STATE OF WASHINGTON
DEPARTMENT OF ECOLOGY

May 18, 2017

Re: PD-16-00001 and LP-17-00004

Thank you for the opportunity to comment during the optional determination of nonsignificance process for the rezone of 4.47 ac parcel to a Planned Unit Development and divide the 4.47 acres into 34 lots. This project is proposed by MDJ Contractors, LLC. We have reviewed the documents and have the following comments.

SHEET CONTENTS
SITE PLAN

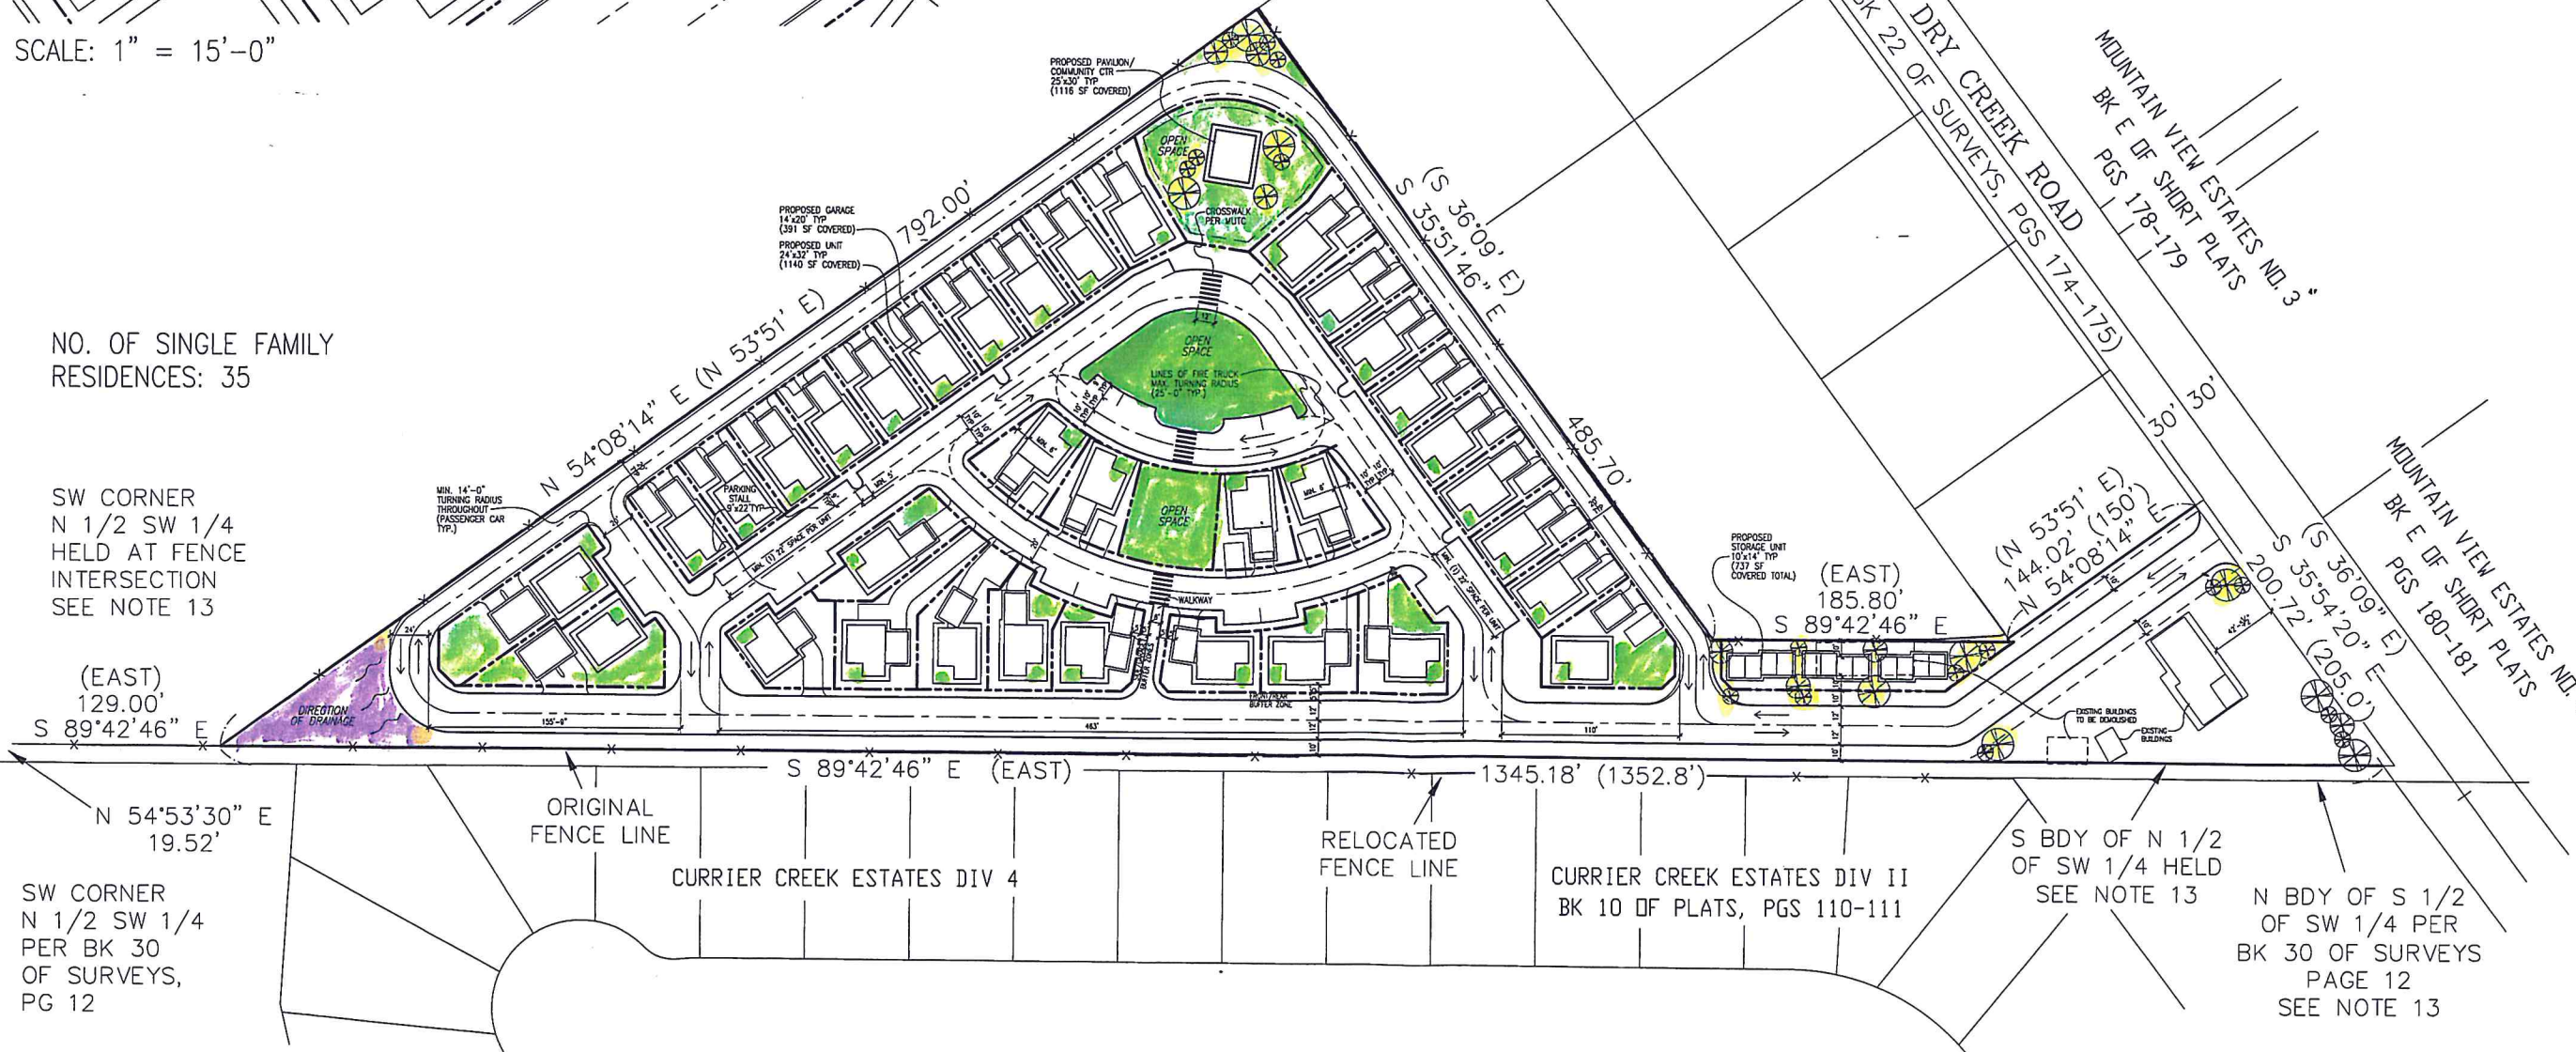
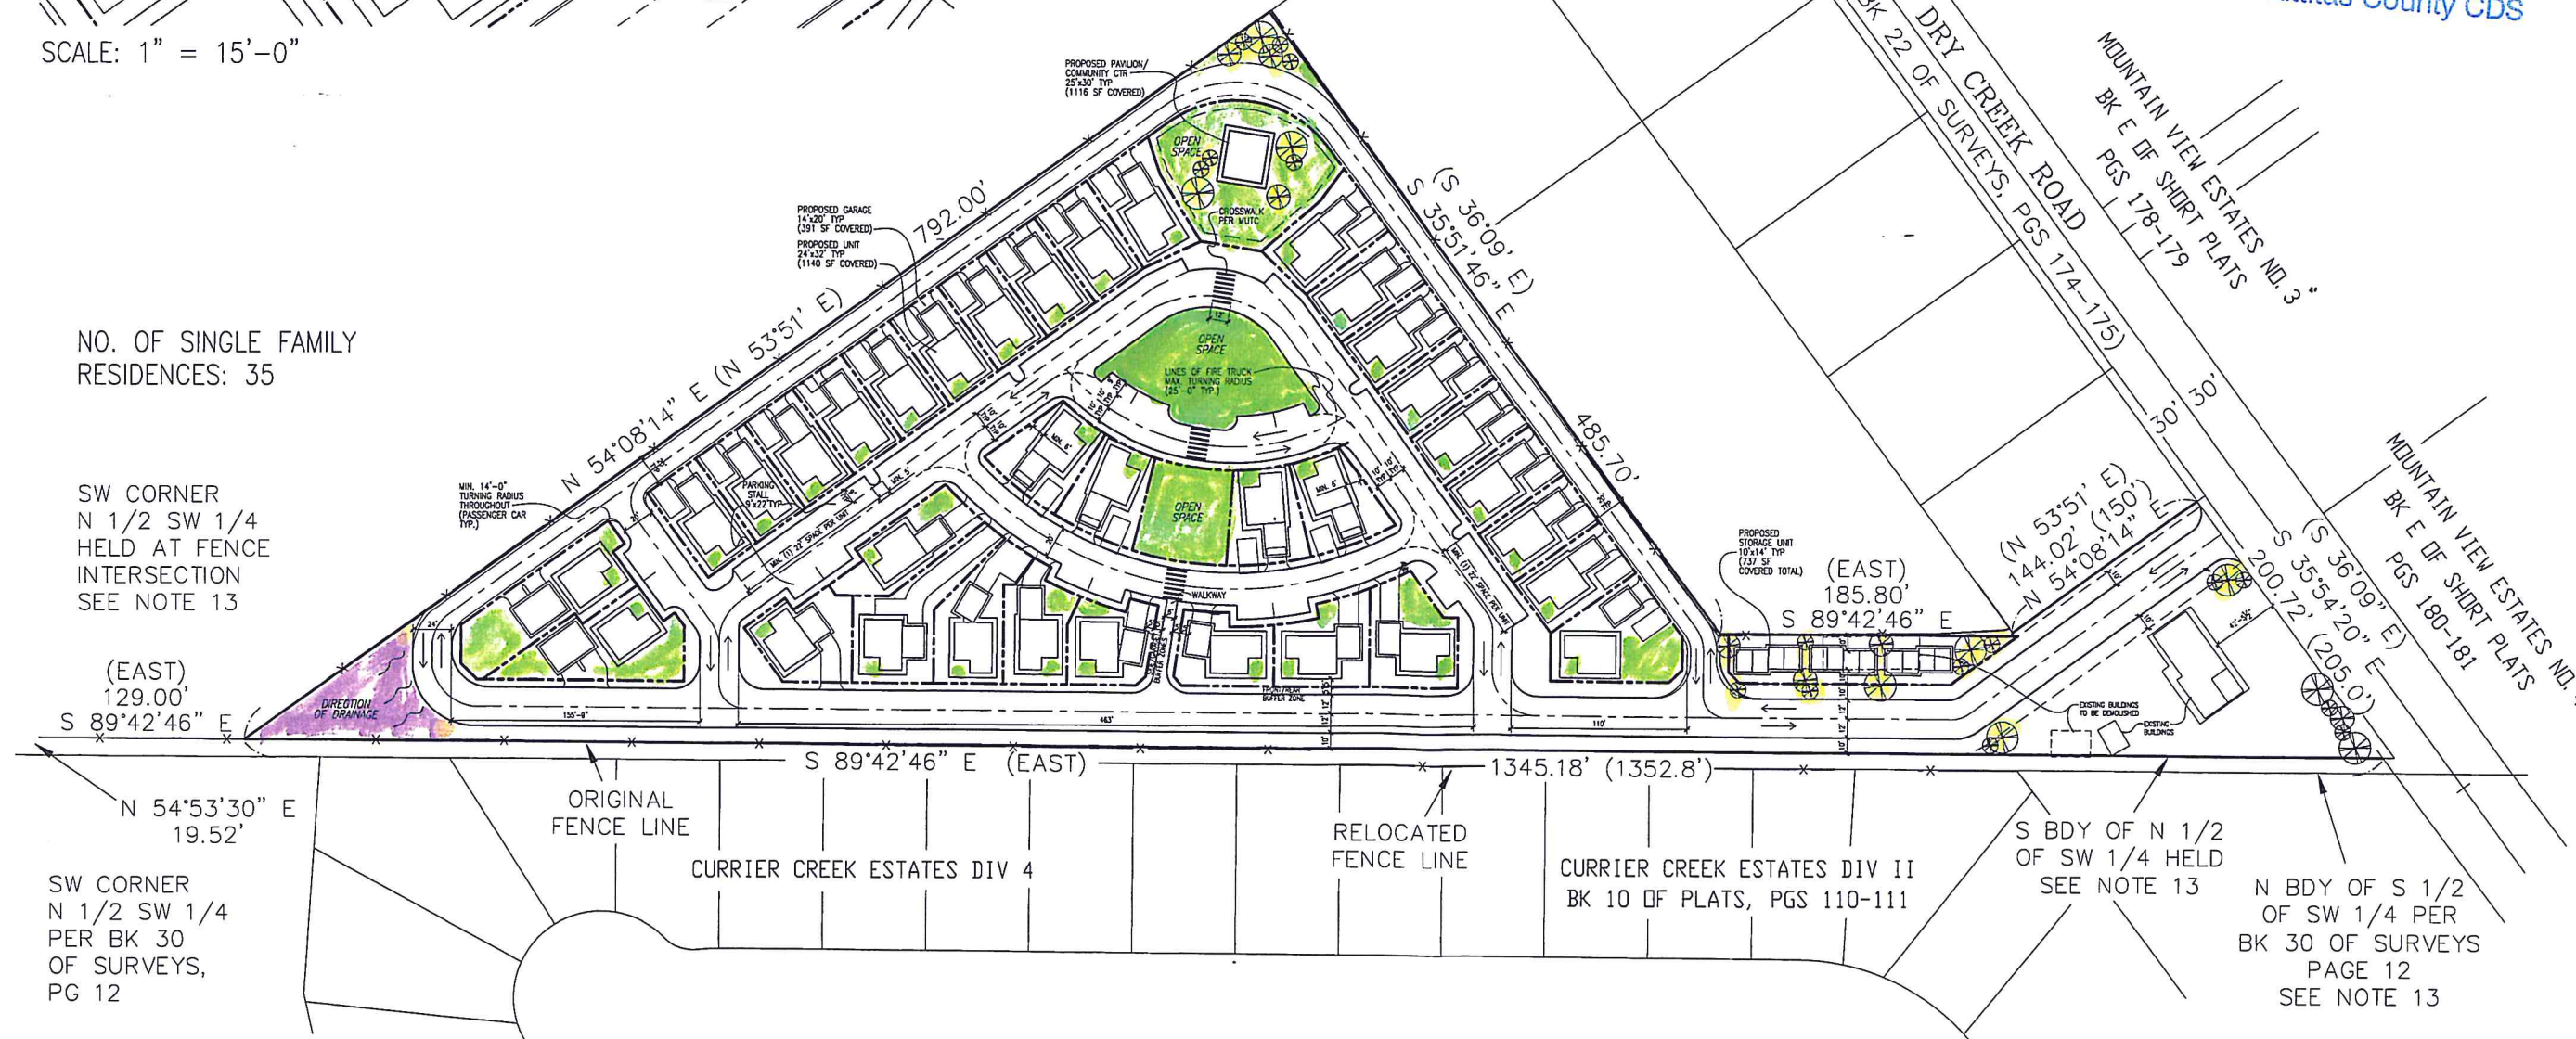
National wetland inventory maps provided at the County website show that this subdivision area is almost 100 percent wetland, but no other mention of the issue is made anywhere else in the other County documents. Was a wetland delineation completed for the site? A wetland delineation should be prepared for the site and available for public review and comment as part of the SEPA process.

Adequate stormwater and flood retention capability should be set aside on site. This is needed in order to protect adjacent wetlands and the water quality of Currier Creek and other downstream waters.
